CITY OF ALBUQUERQUE

RE: VISTA WEST SUBDIVISION, (L-10/D23)
Engineers Certification for Release of Financial Guaranty
Engineers Stamp dated 07/31/2003
Engineers Certification dated 06/14/2006

RE: VISTA WEST SUBDIVISION, (L-10/D23)
Engineers Certification for Release of Financial Guaranty
Approved Engineers Stamp dated 08/08/2002
Submitted Engineers Stamp dated 07/31/2003
Engineers Certification dated 06/14/2006

Re: Vista West Subdivision Drainage Report
Engineer's Stamp dated 8-8-02 (L10/D23)

REVISIONS	DESIGN	DATE	BY
1	DESIGN	07/31/03	NIL
2	DESIGN	07/31/03	NIL
3	DESIGN	07/31/03	NIL

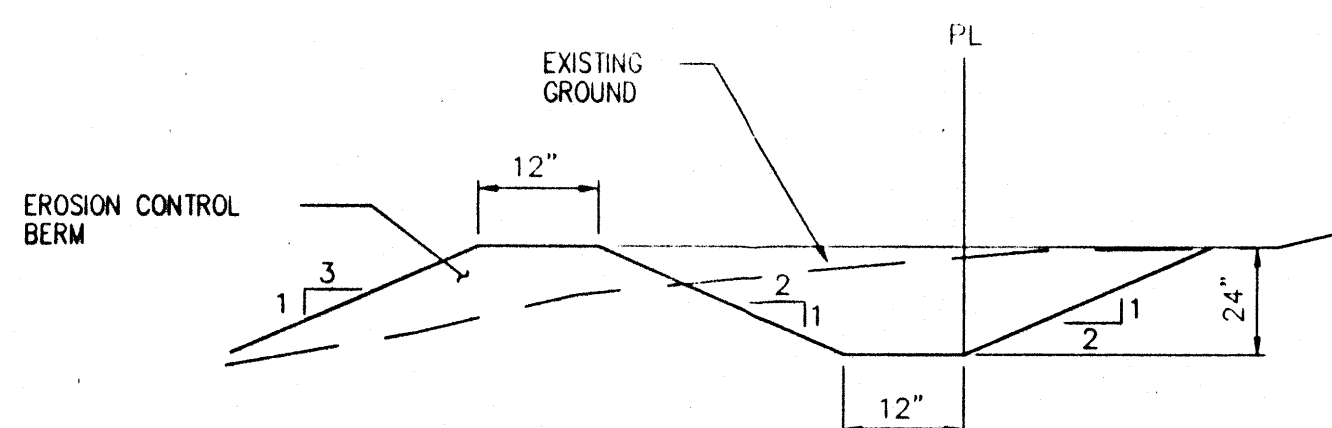
Based upon the information provided in your Engineer's Certification Submittal dated 06/14/2006, the above referenced plan cannot be approved for Grading and Drainage Certification for Release of Financial Guaranty.

1. The Approved Grading and Drainage Plan has an Engineer Stamp date of 08/08/2002 not 07/31/2003 as indicated in your submittal. (See attached copy of approval letter and copy of lower right hand corner of approved G/D Plan).

Based upon the information provided in your Engineer's Certification Submittal dated 06/19/2006, the above referenced plan is adequate to satisfy the Grading and Drainage Certification for Release of Financial Guaranty.

TEMPORARY RETENTION POND DETAIL

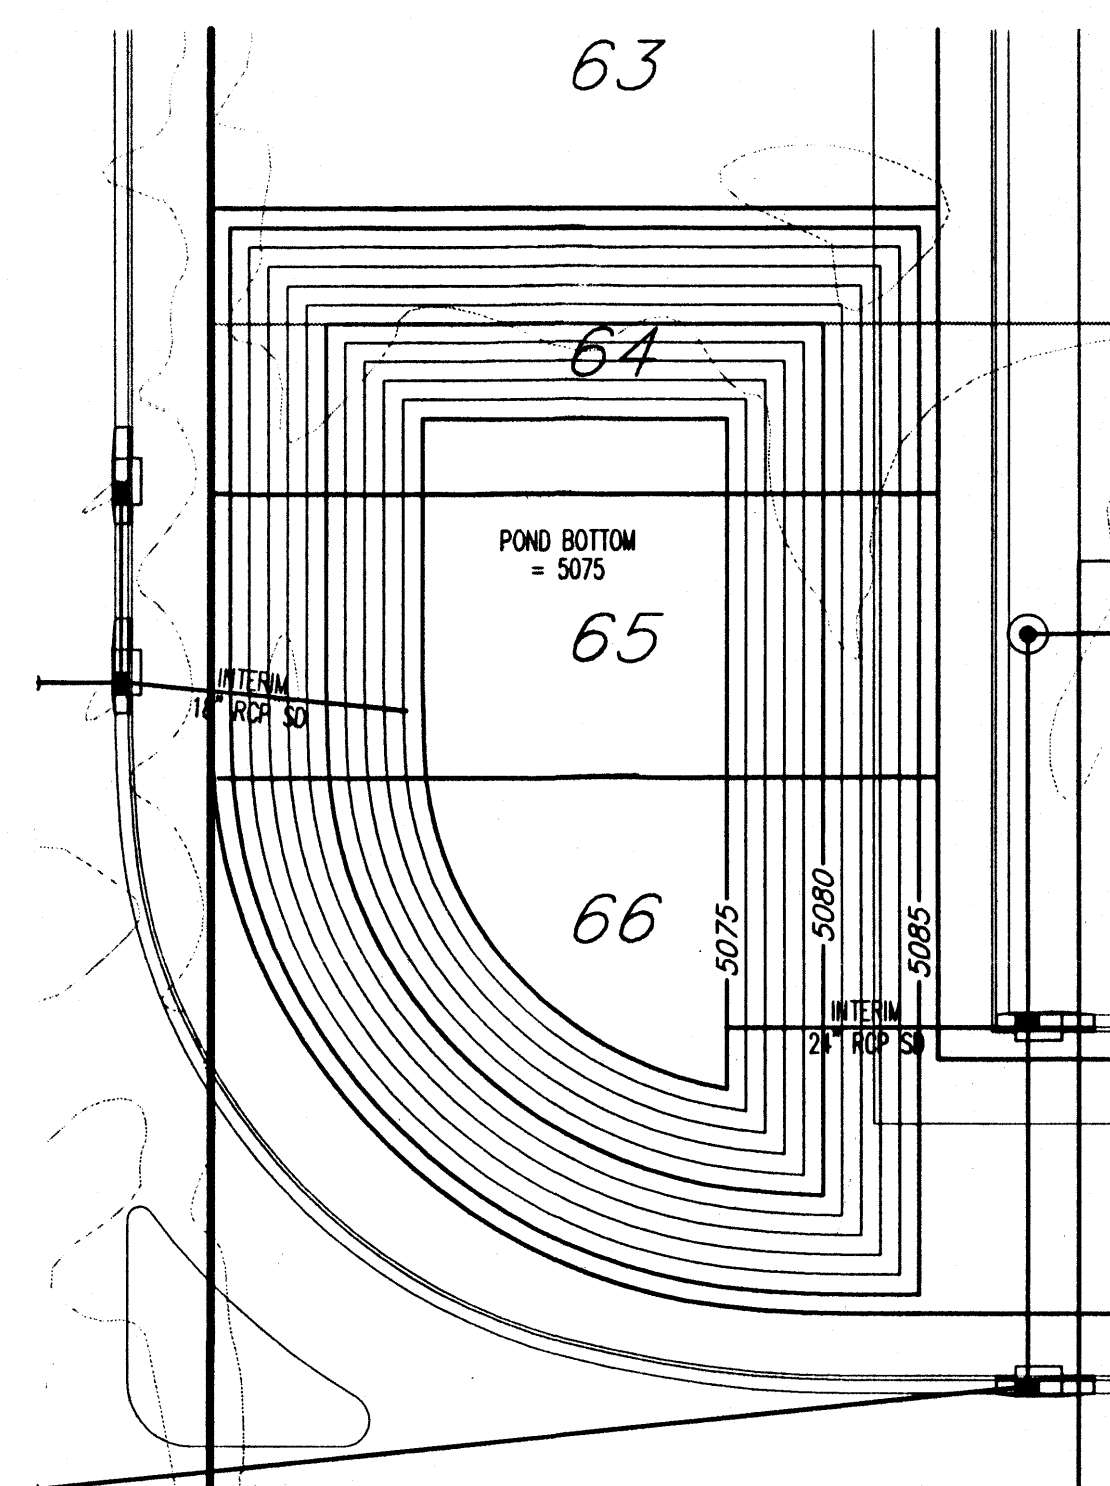
Based upon the information provided in your submittal dated 6-3-02, the above referenced report is approved for Preliminary Plat action by the DRB. However, prior to Final Plat or Work Order, the proposed pond must be analyzed for the 100-yr, 10-day volumes, not the 100-yr, 6-hr volumes as stated in your report.
